Recommendation Report for Planning Permission

REF NO: FG/141/19/PL

LOCATION: Elm Lodge
Tamarisk Way
Ferring
BN12 5ER

PROPOSAL: Erection of 1 No detached chalet style dwelling with integral garage; demolition of existing conservatory & porches & erection of single storey side extension & part single/part two storey side extension to Elm Lodge (resubmission of FG/220/18/PL).

PROPOSED WEST (SIDE) ELEVATION 1:50.

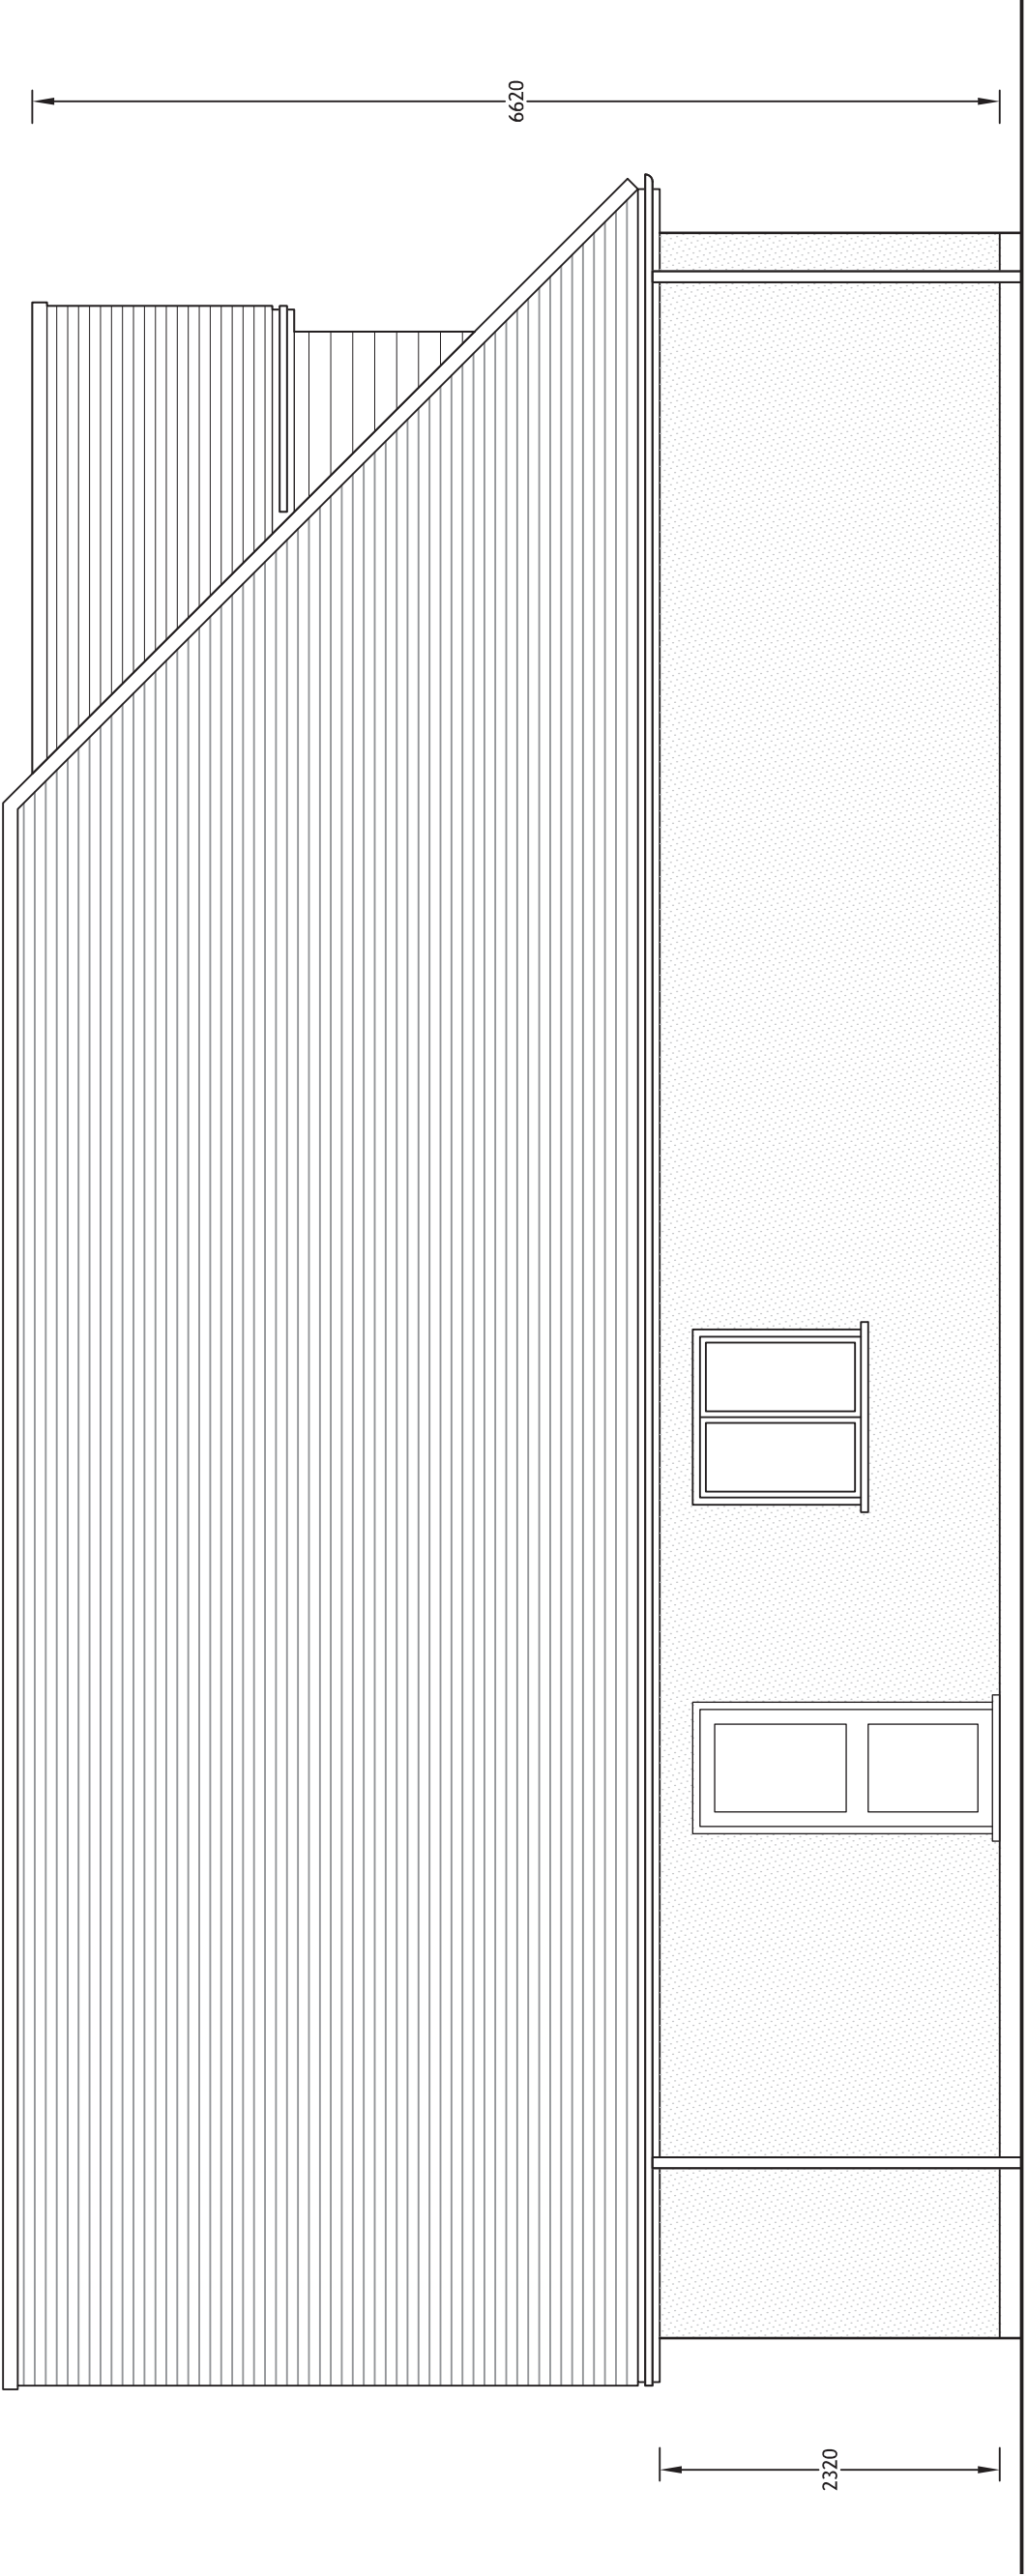
Although the roof nearest Elm Lodge has been changed to a hipped roof, due to the necessity to locate the property a prescribed distance from the pond the proposed dwelling would have a cramped appearance on the site in relation to the existing dwelling Elm Lodge. The cramped dwellings would be visible from a considerable distance from the south along Sea Lane and would have an unacceptable impact on the visual amenities of the surrounding area.

The proposed dwelling has a length of approx. 14m at a distance of 1m from the common boundary with Elm Lodge. At an eaves height of 2.3m and ridge height of 7m in such close proximity would result in an overbearing effect on the occupiers of Elm Lodge by way of the proposed building height, mass, and proximity to the host property. Efforts have been made to overcome the Inspectors reason for refusal in terms of overlooking but it is not felt the changes made are enough to overcome this previous reason for refusal in terms of overbearing and unneighbourly effects on the residents of Elm Lodge.

PROPOSED SOUTH (FRONT) ELEVATION 1:50.

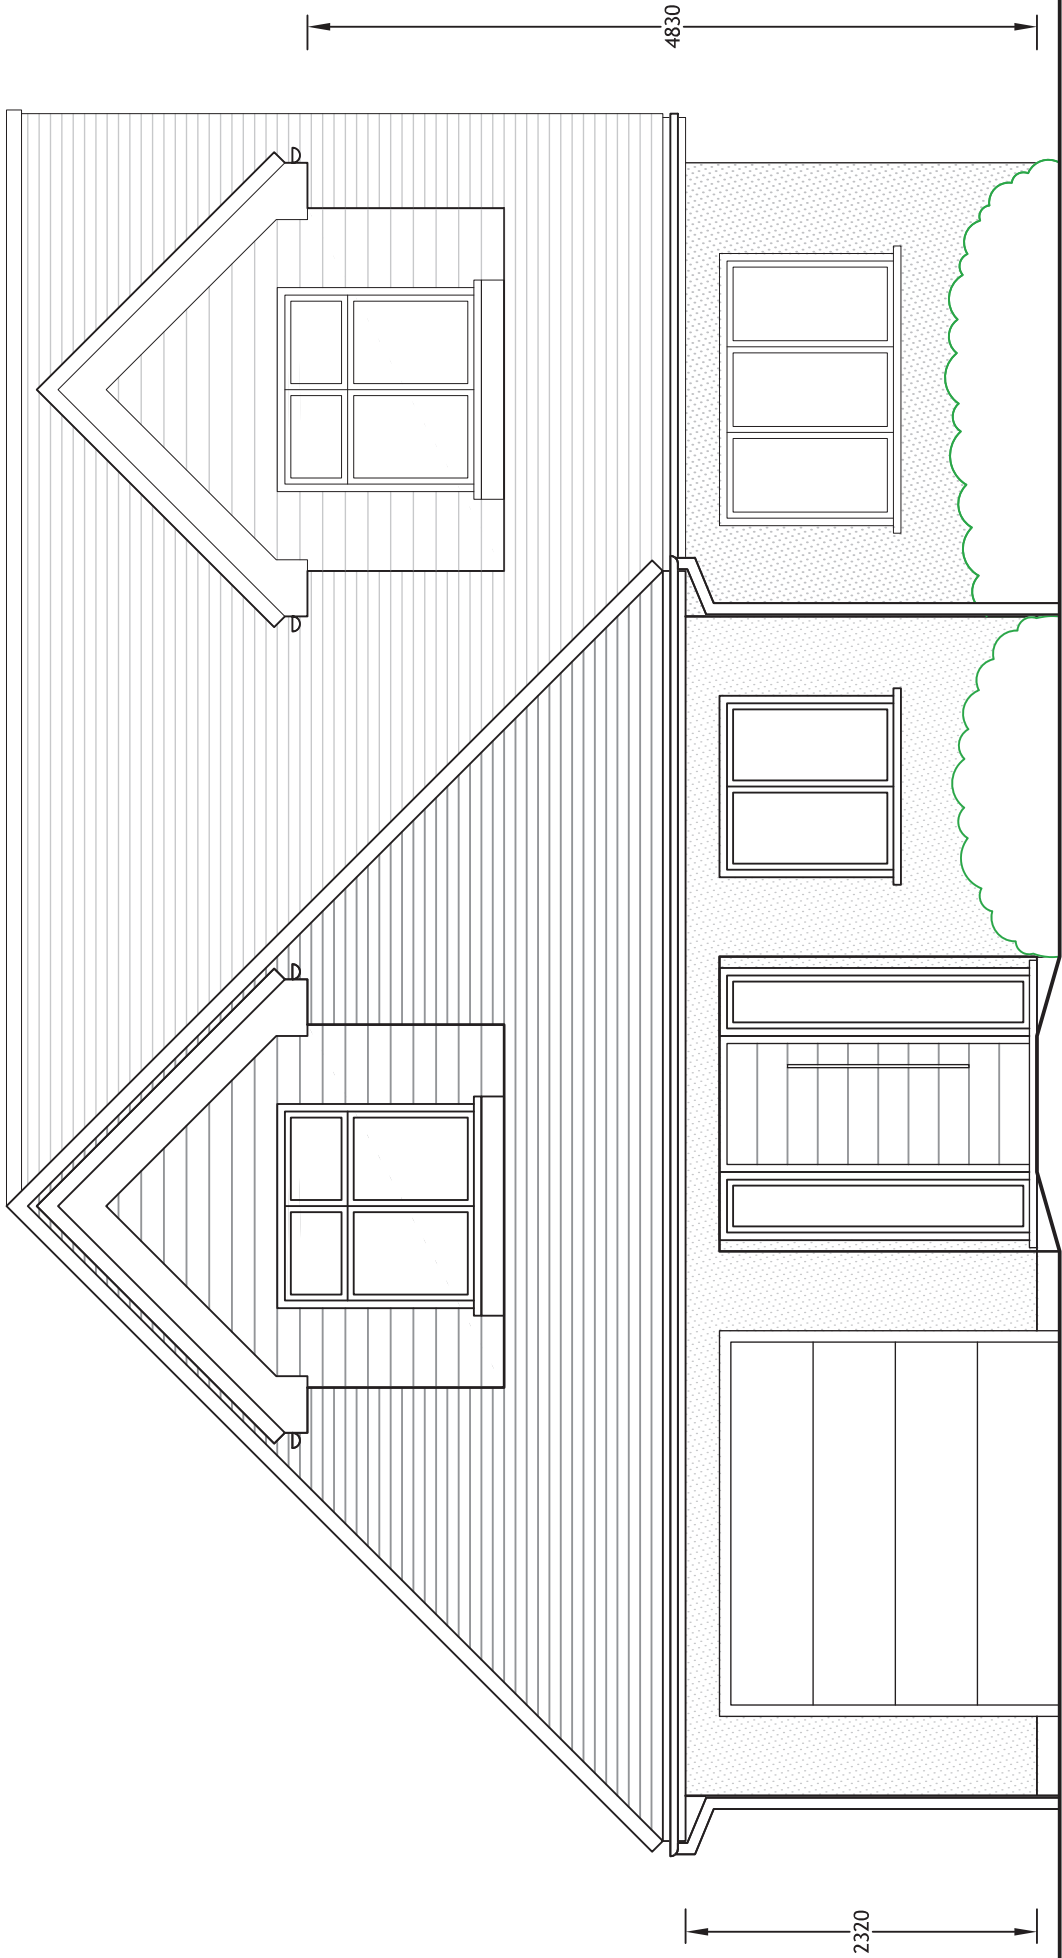
The chalet bungalow opposite (Magalia) has a similar layout to the existing dwelling, Elm Lodge such that the primary garden space is located to the front of the dwelling facing onto Sea Lane. The cumulative impact of these dormer windows for bedroom 3 and the master bedroom at a distance of 15 and 18 metres respectively from Magalias garden area would be unacceptable. Magalia's primary garden area is currently not overlooked at all. The proposal would cause an unacceptable loss of privacy to this amenity space.
